**Amended Concept Development Application (SSD-9579) for an Over Station Development (OSD) above the new Crows Nest Metro Station including maximum building envelopes, gross floor area, conceptual land uses, car spaces and signage zones.**

**Supplementary Submission by Wollstonecraft Precinct Committee (to Preliminary Submission lodged by closing date of 6 October 2020)**

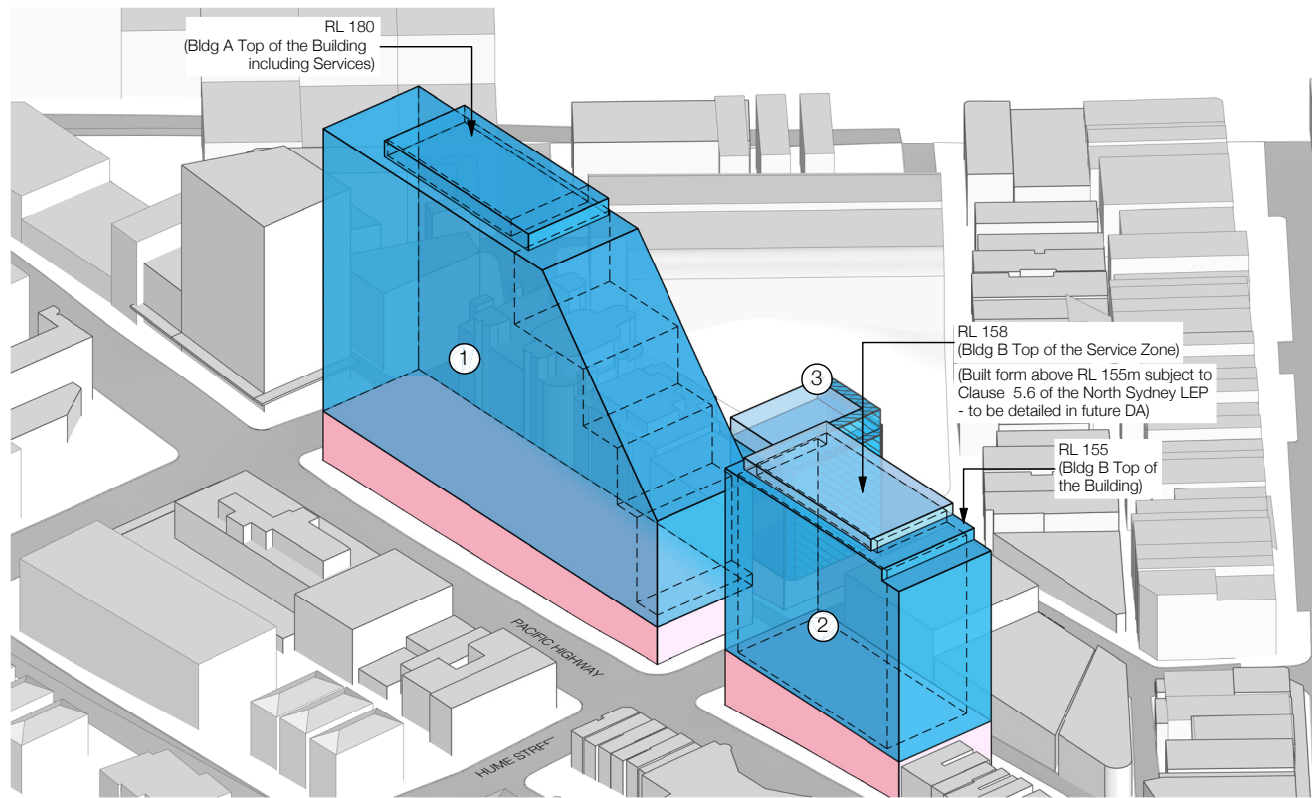
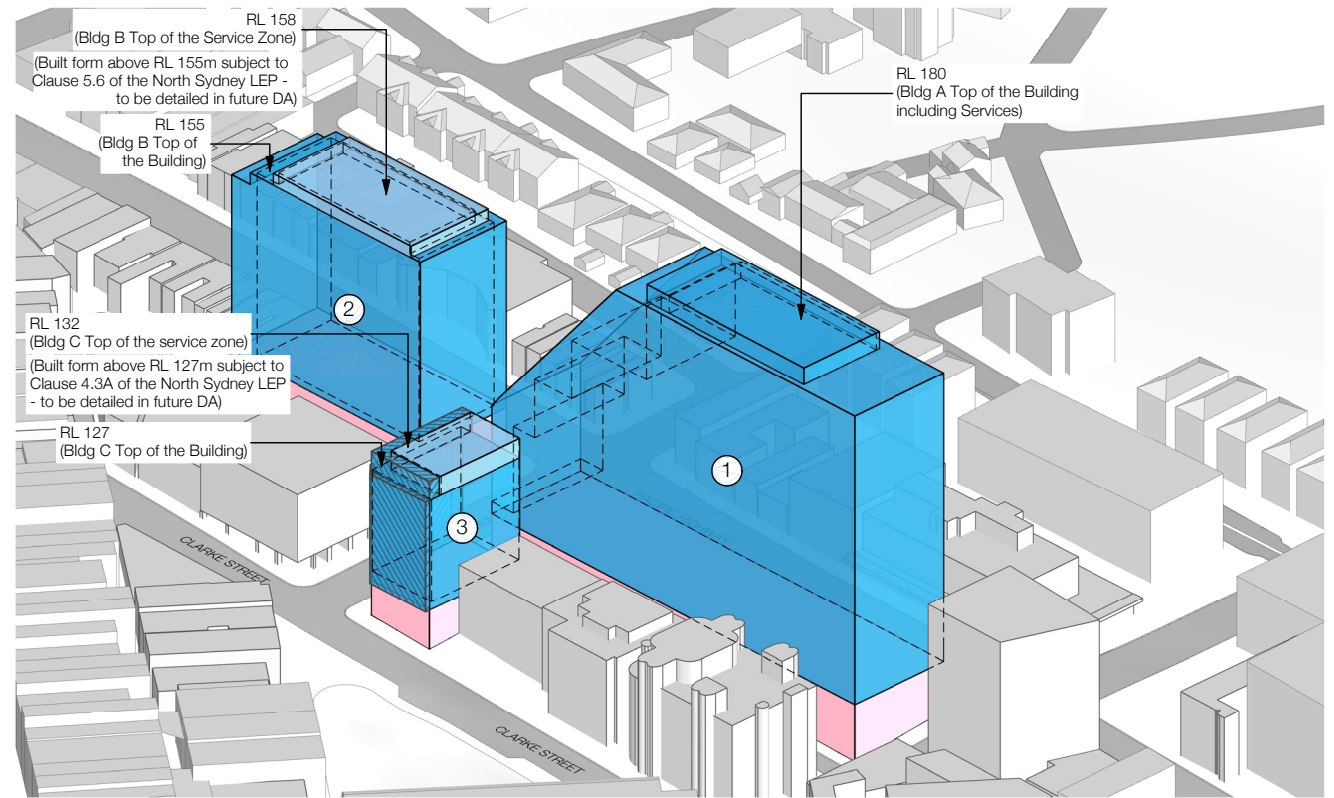
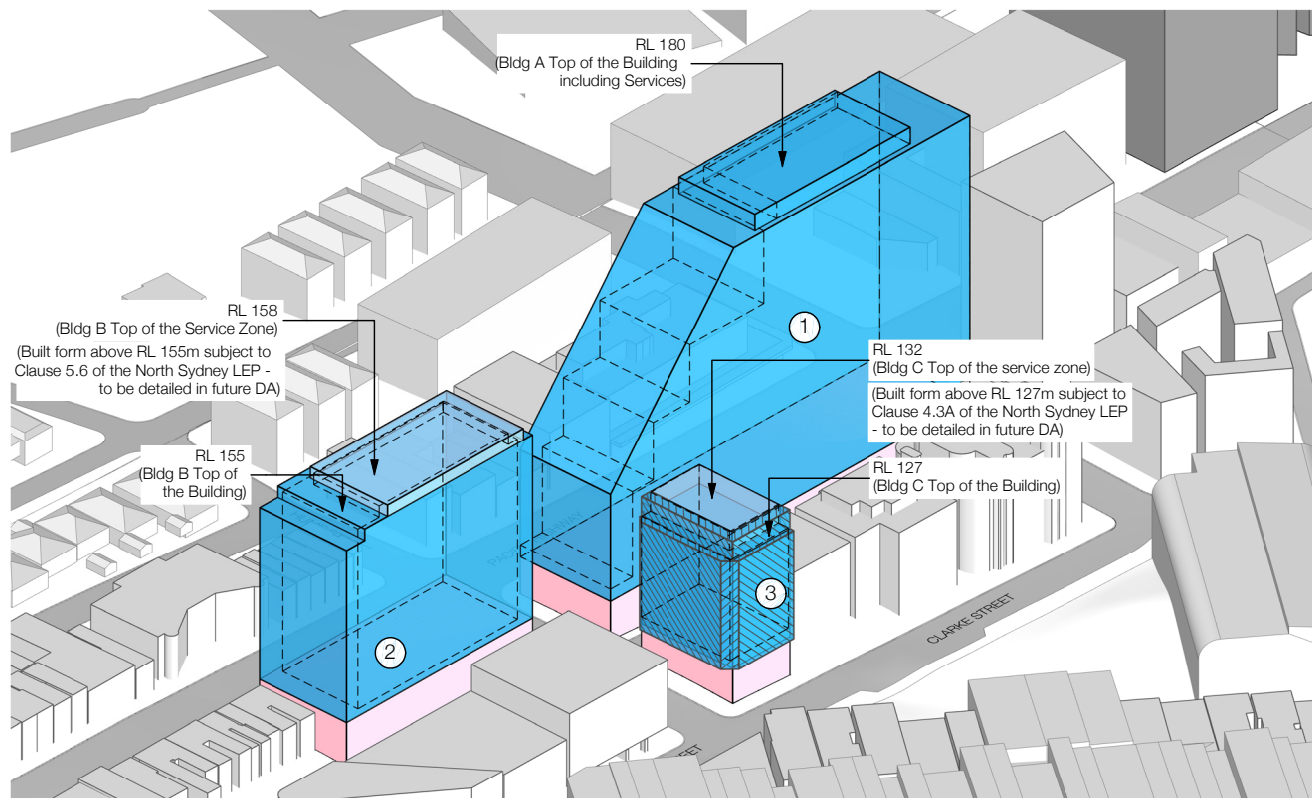
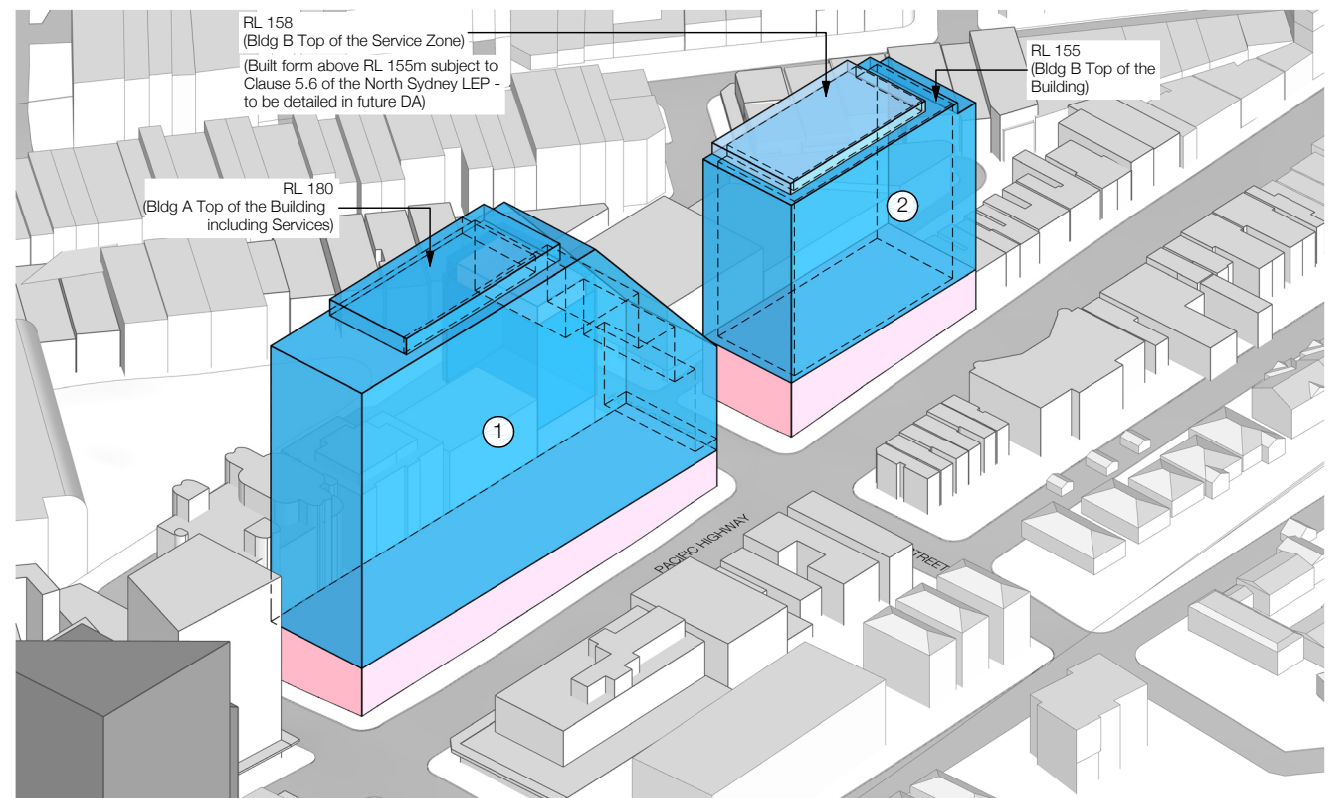
Photomontage of the Amended OSD Project showing Buildings A & B atop the Station Podiums  
Note: a) the sign on Building A hides the top section to give an impression of reduced bulk and  
b) the impression of a vertical gap in the middle of the building that is not supported by the indicative plans .

The two images are shown at different scales which gives a misleading impression that the amended project is very much smaller than originally exhibited. Yet, the only change to the envelope is a height reduction of 7.6 metres to Building A and a truncation of the south face, offset by elimination of the large vertical gap between the two towers as originally exhibited. According to Sydney Metro this envelope is 20% less than the original proposal. However, it is one building, not two and will be a very imposing frontage over the full block. In reality its bulk is reduced by 6% not 20%.

The claimed 20 percent reduction in the building envelope is challenged as being misleading because it ignores comparison of the net area of the east west faces of the commercial building on Site A with the same faces of the residential building as originally exhibited. Our conservative analysis is shown on Attachment 'B'. The summary is as shown below:
